Your Ref: SSI 9775
Our Ref: D18/8429
DA18121016489 MA

31 July 2019

Part 3A/State Significant Development Application - Maitland Hospital - Metford Road, Metford

FIGURE 5 – ASSET PROTECTION ZONE

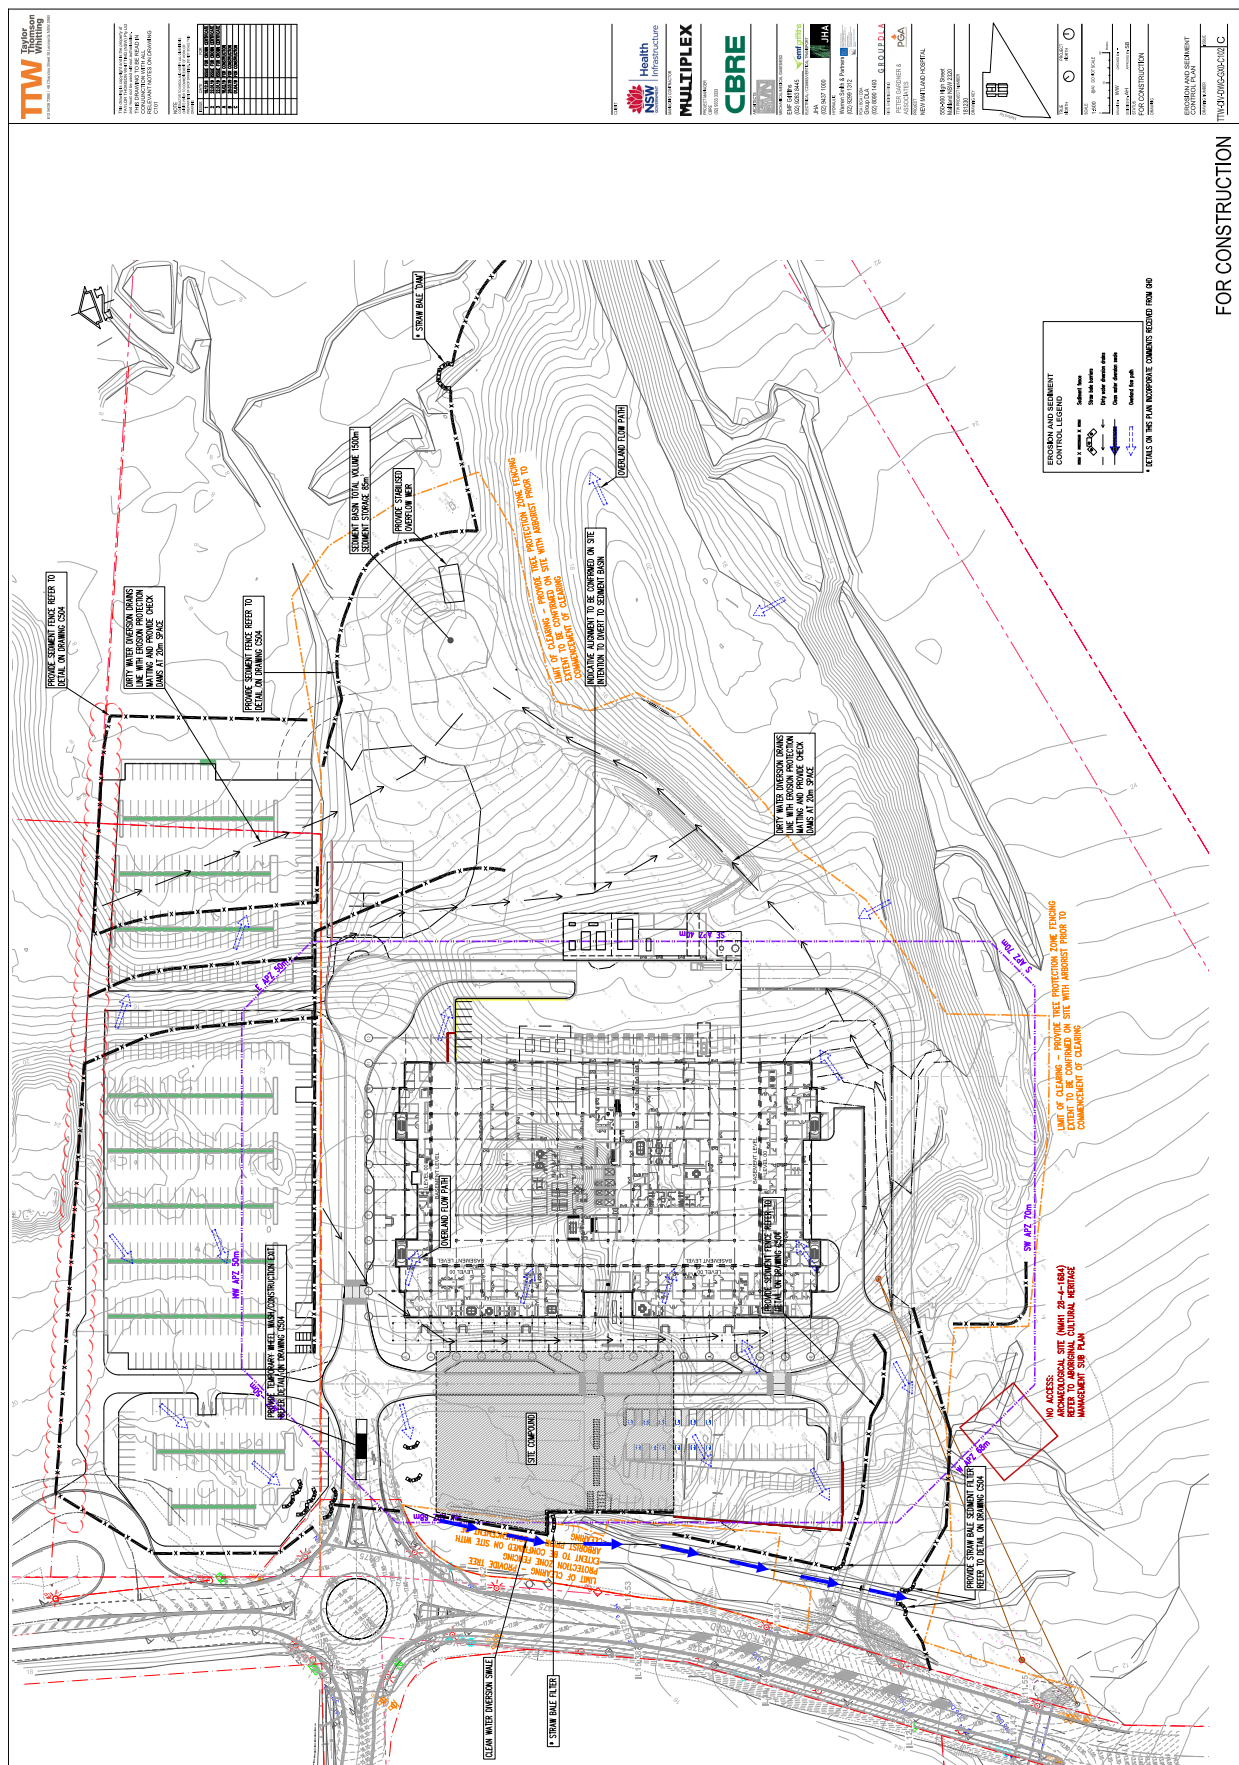
1. At the commencement of building works and in perpetuity the area surrounding the building for the following distances;

- 40 metres to the south east
- 50 metres to the east and
- 68 metres to the west

shall be managed as an inner protection area (IPA) as outlined within section 4.1.3 and Appendix 5 of 'Planning for Bush Fire Protection 2006' and the NSW Rural Fire Service's document 'Standards for asset protection zones'.

2. At the commencement of building works and in perpetuity the area surrounding the building for the following distances;

- 60 metres to the south and south west

shall be managed as an inner protection area (IPA) and an additional

- 10 metres

shall be managed as an outer protection area (OPA) as outlined within section 4.1.3 and Appendix 5 of 'Planning for Bush Fire Protection 2006' and the NSW Rural Fire Service's document 'Standards for asset protection zones'.
